Major Projects – New Request for Advice - Western Sydney University Bankstown City Campus (SSD-9831) (Canterbury-Bankstown)

Thank you for your correspondence via ePlanning Portal (ref: PAE-1033) dated 1 November 2019 requesting Transport for NSW (TfNSW) to provide advice in relation to the subject development. Please accept this letter as a joint response from Transport for NSW (TfNSW) and Roads and Maritime Services (Roads and Maritime).

Transport Management and Accessibility Plan

DRAWING TITLE  
**PLAN - BASEMENT 1**

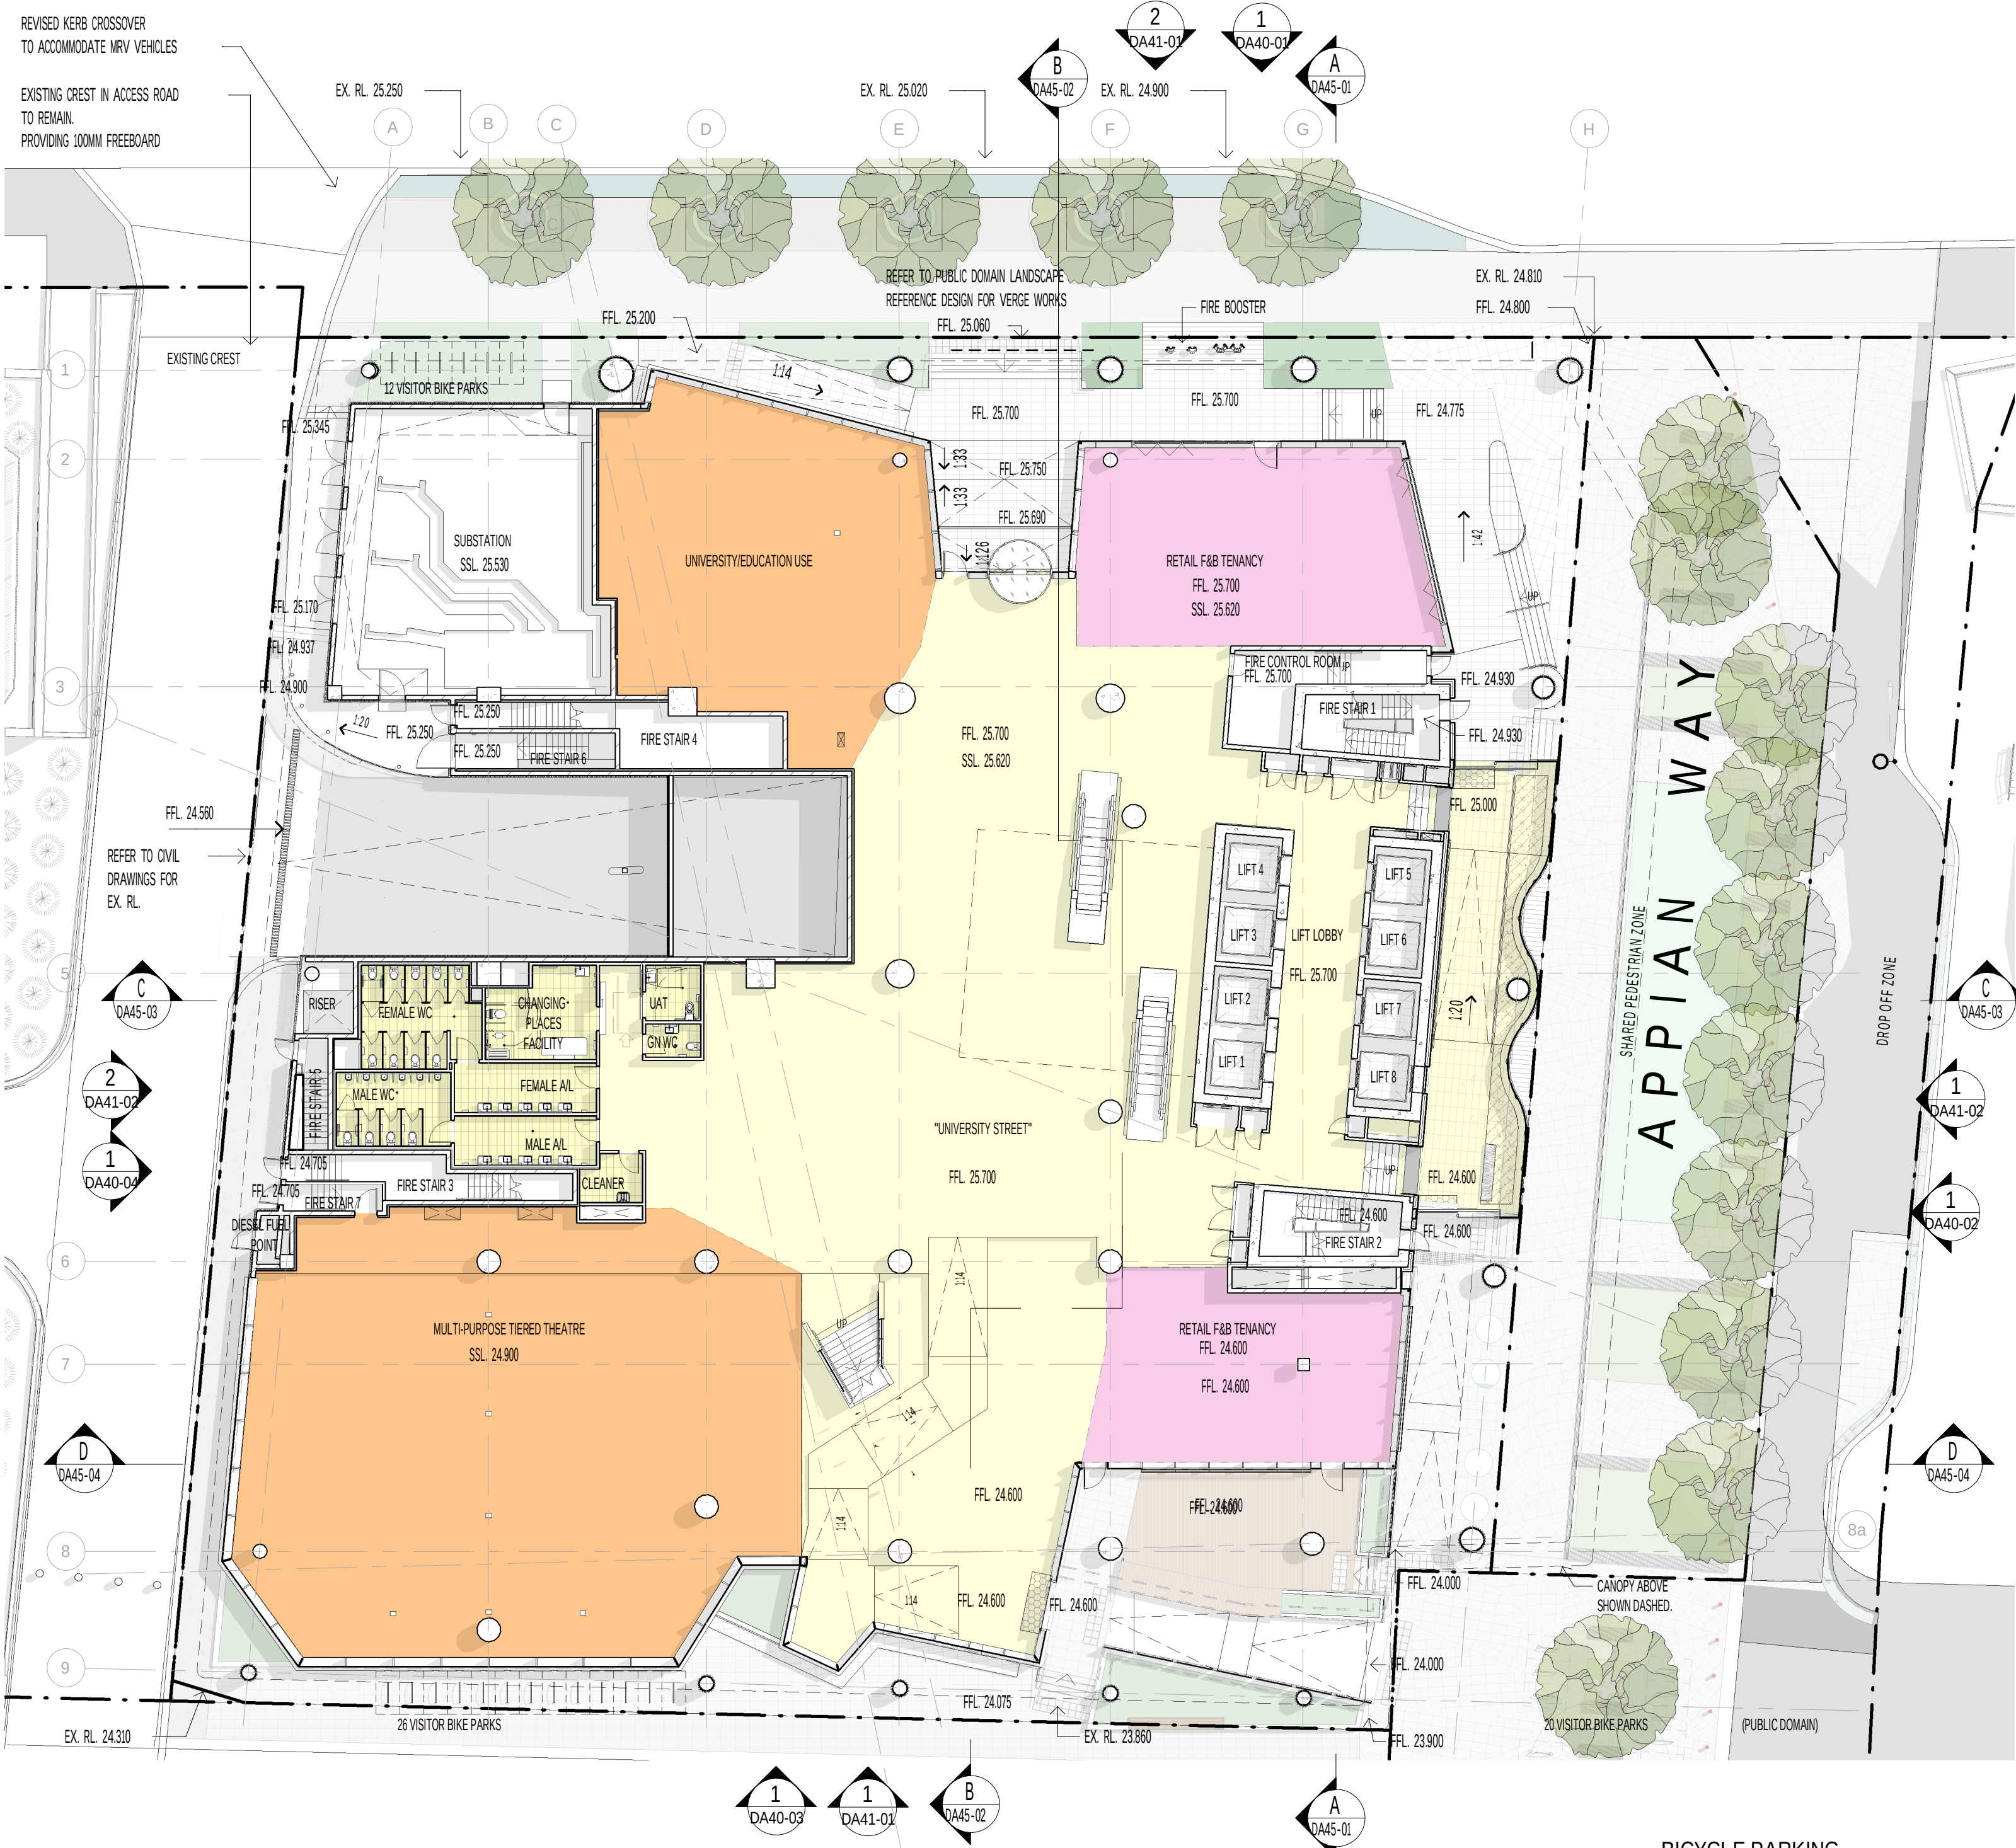
Plans show that card readers will be used for access to the basement area. It appears from the plans that vehicles will need to travel to the contraflow direction to access the relevant card reader. This will present a safety issue when vehicles require access and egress at the same time.

It is recommended that the design of the basement vehicle entry be reviewed and if necessary re-designed to allow for a central median that will accommodate both entry and egress card readers, thus eliminating vehicle conflict.
